KITTITAS COUNTY FIRE MARSHAL'S OFFICE

Re: Suckert (BL-14-00014)

After conducting a review of the recent changes to the above named project, I have the following comments:

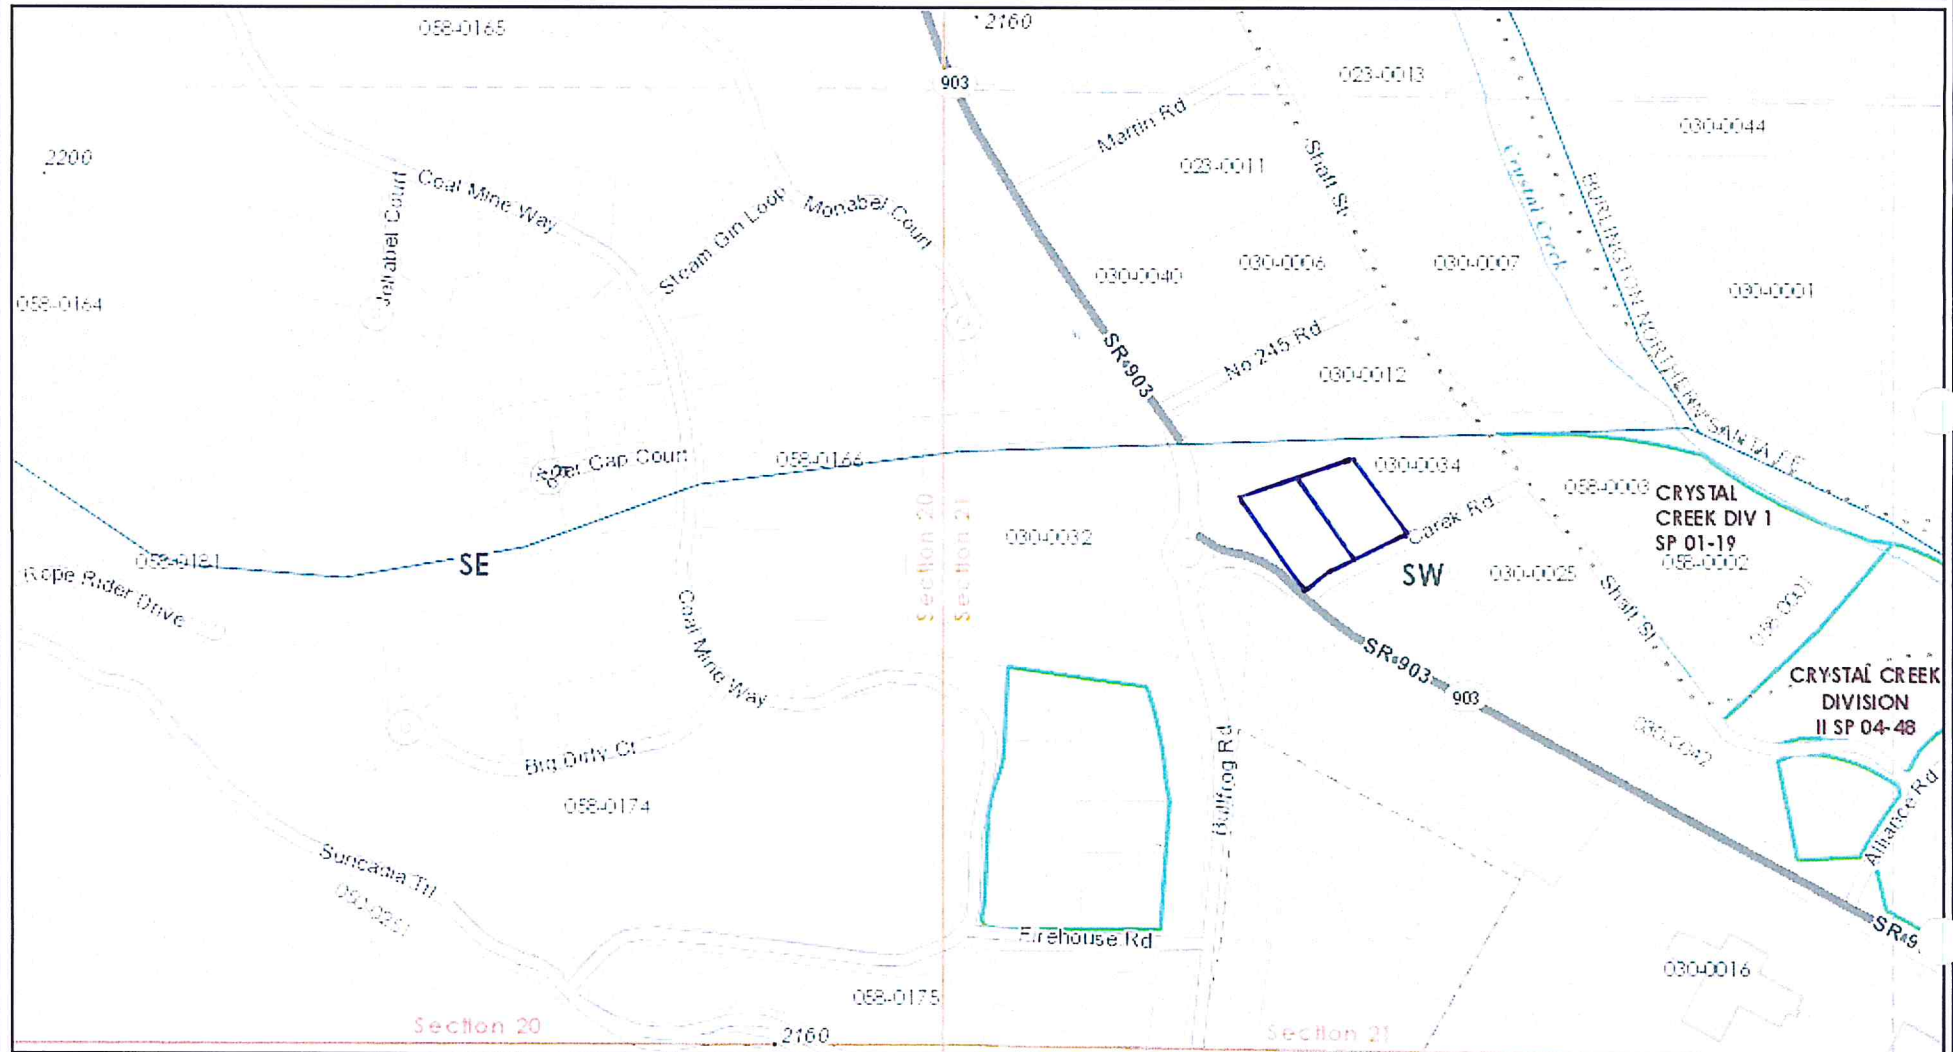
- Ensure that boundary line adjustments do not infringe upon existing structures, to include propane tanks, etc.
- Ensure adequate access for fire apparatus. Any driveways or access points created based off the new lot configurations shall comply with Kittitas County Code 20.02.030.
- All future development must comply with the International Fire Code.
